Our Ref: EP/55/12/

1 no. new dwelling

Land adjacent to 20 Eastern Close East Preston

PROPOSED DWELLING - ON LAND ADJACENT TO No. 20 EASTERN CLOSE

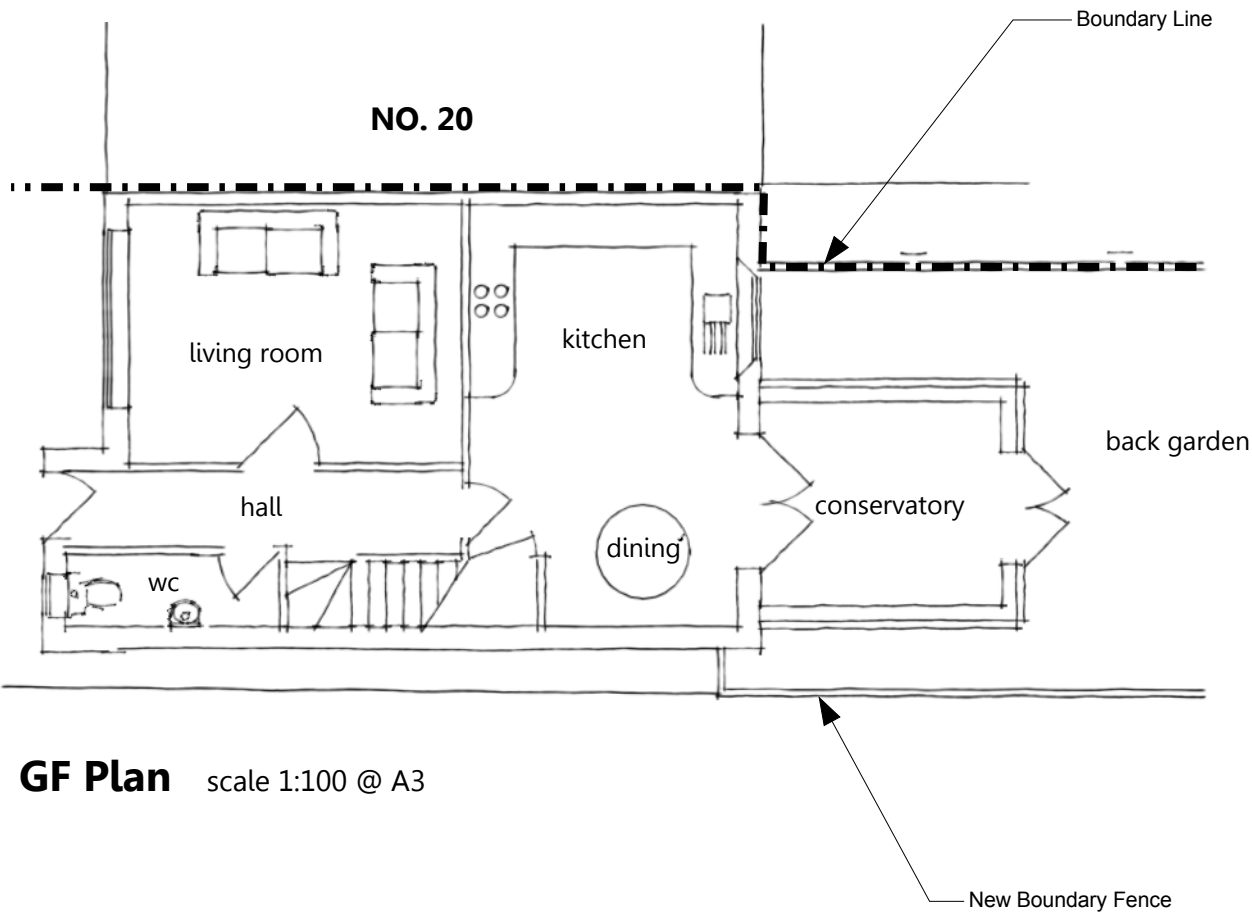
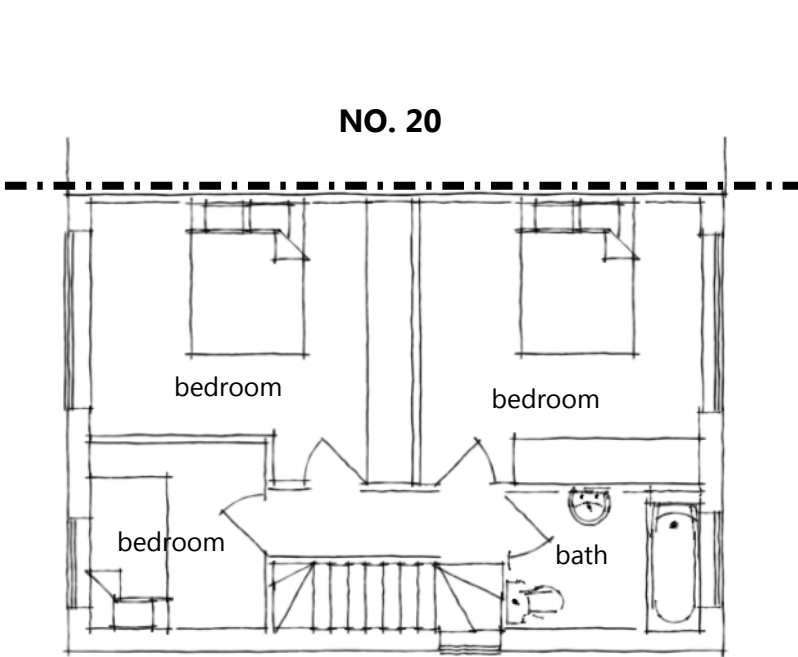
¿ Overlooking ¿ The back bedroom window of the new house will enable a view point into our living room, and front bedrooms where our children sleep.

¿ Overlooking ¿ the window on the plans on the south side wall would look directly into our living room and two front bedrooms.

PROPOSED DWELLING - ON LAND ADJACENT TO No. 20 EASTERN CLOSE

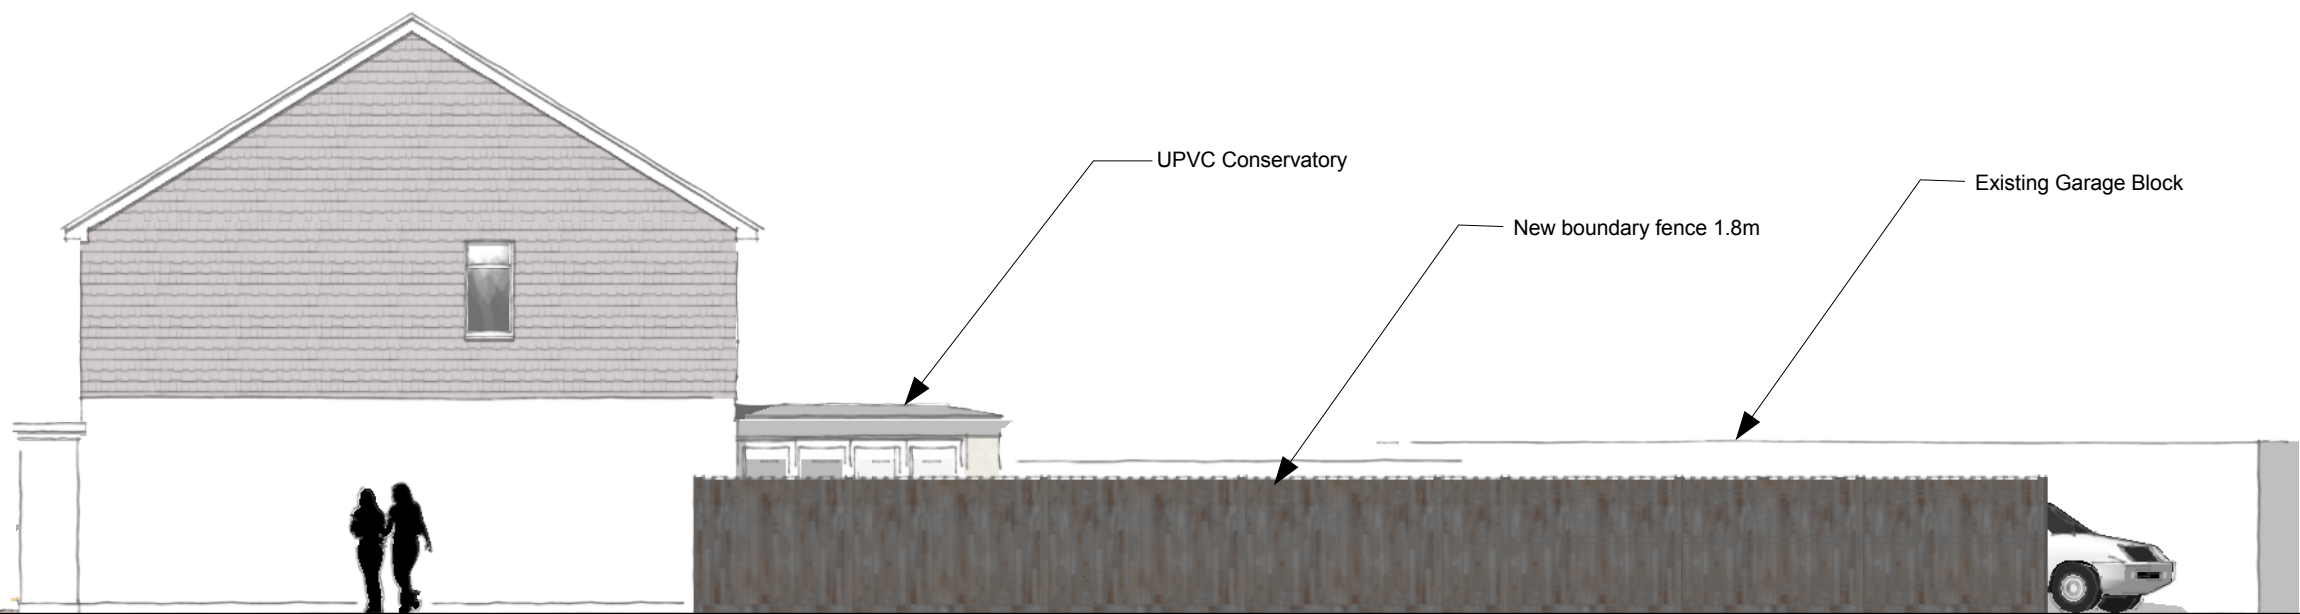
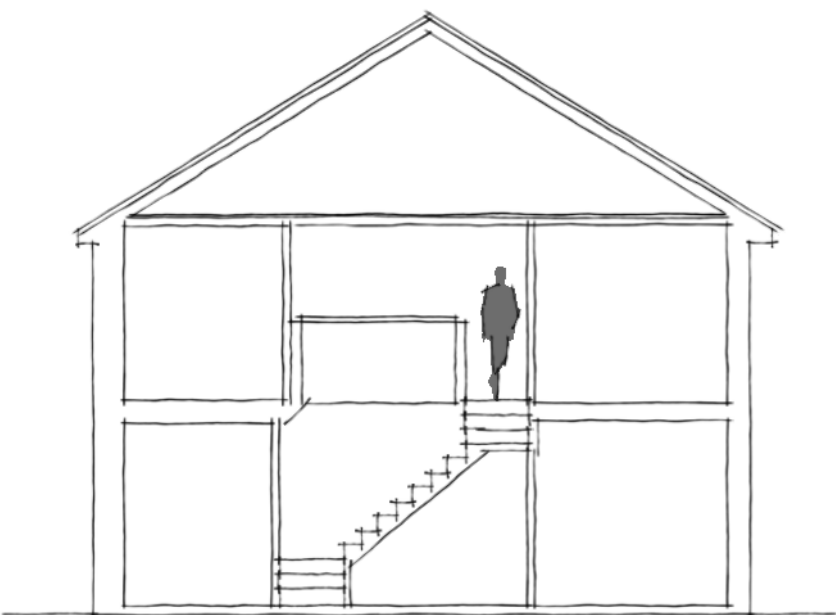
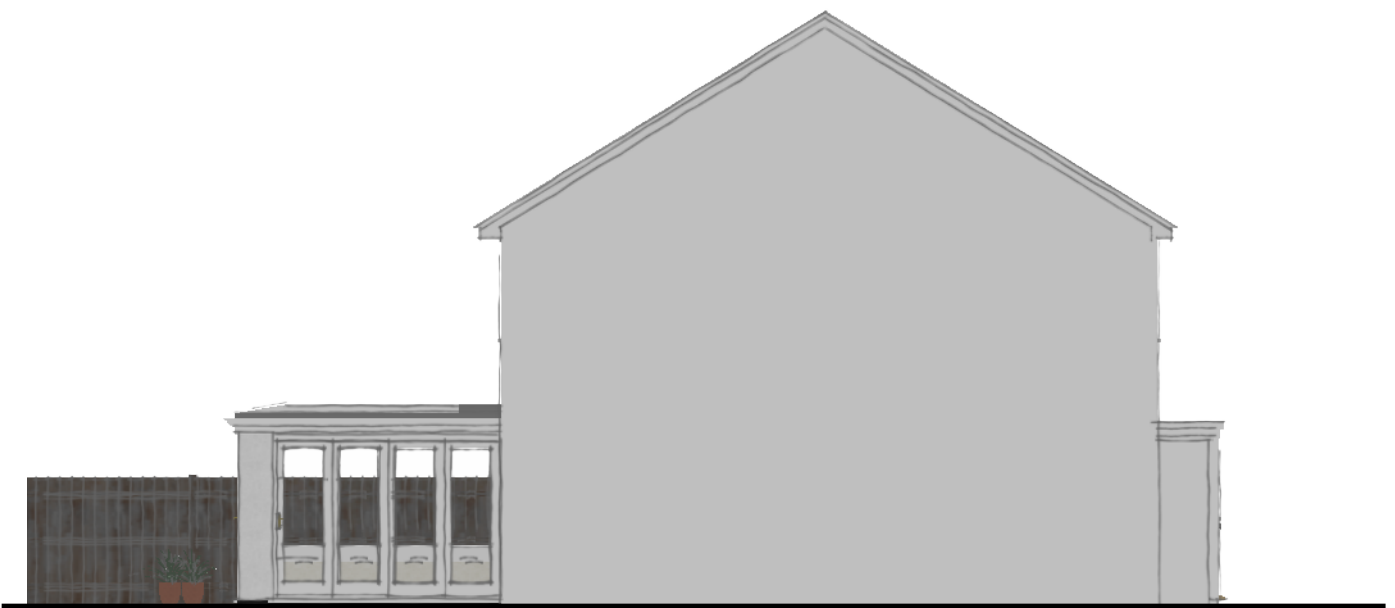
The proposed building will look out of place, casting shadow on the opposite houses. It will not be in symmetry with the design of the original housing design. □
